Planning Officer: Mr F Gardner
Planning Application Ref: FP/154/19/T
Location: 33 Roundle Avenue, Felpham, PO22 8LL
Description of works: Crown reduction by 3.5m - 4m to 1no. ash tree
Reasons Given: None provided

33 ROUNDLE AVENUE

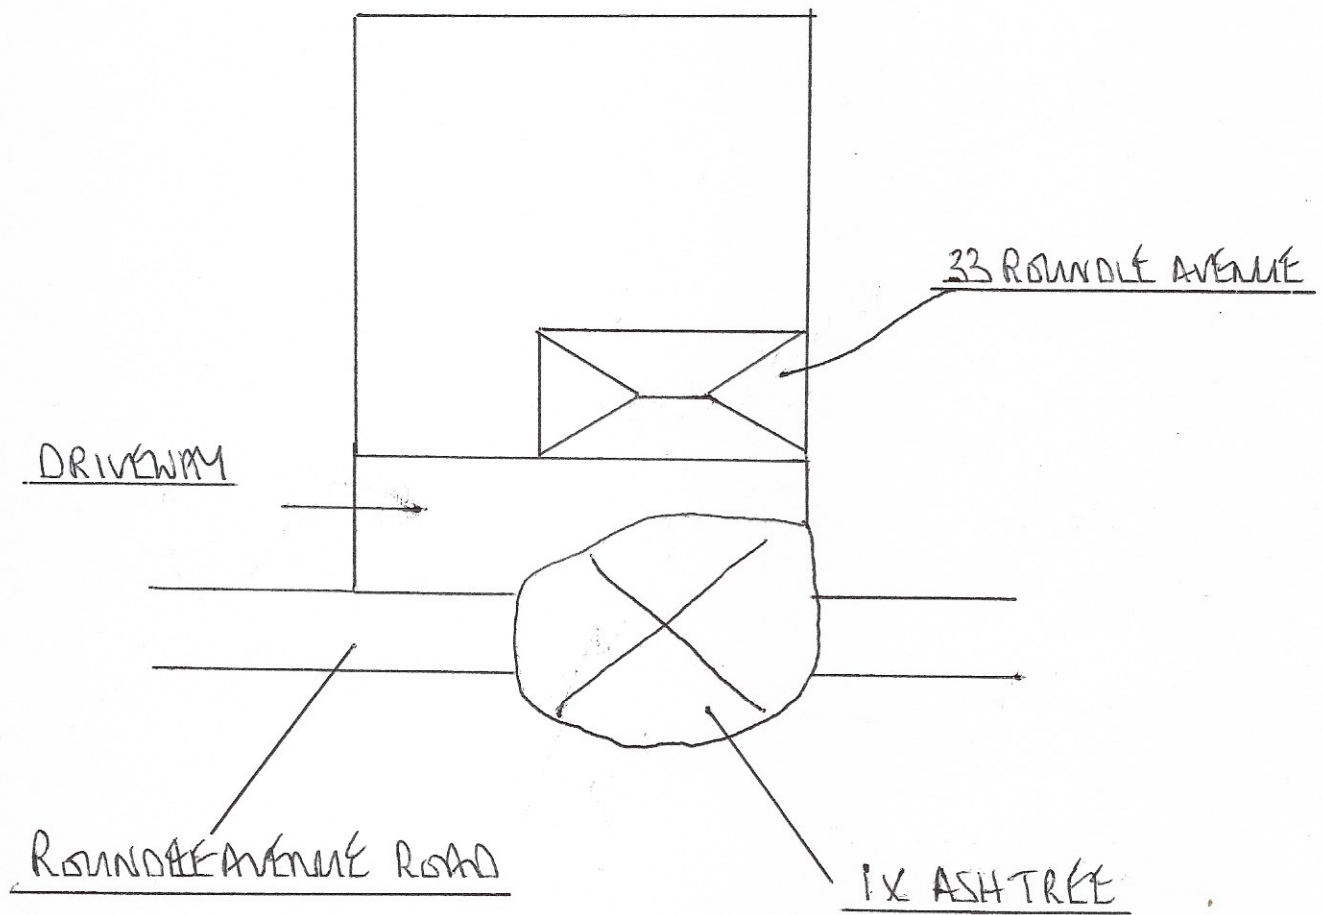
- This tree had been 'topped' at around 5m height but has grown-on well and presents an attractive crown profile. Outwardly and from a distance it appears to be in a fine physiological state and structurally sound.
- It grows at the front of the property and is prominent roadside, being visible from both numerous properties and to traffic across this part of the estate. As such, it has public amenity value.

- The tree work proposed in the application has not been justified on arboricultural grounds.
- The tree is a significant feature in the local landscape and appears to be in adequately sound and healthy condition. The tree surgery proposed in the application would result in excessive reduction of the tree's landscape impact and undue detriment to the visual amenities of the locality.
- No reasons have been provided in support of the work proposal. I am unable to advise appropriate lesser works at this time without the applicant's stated aim(s) in mind.

- I recommend **REFUSAL** for this application.
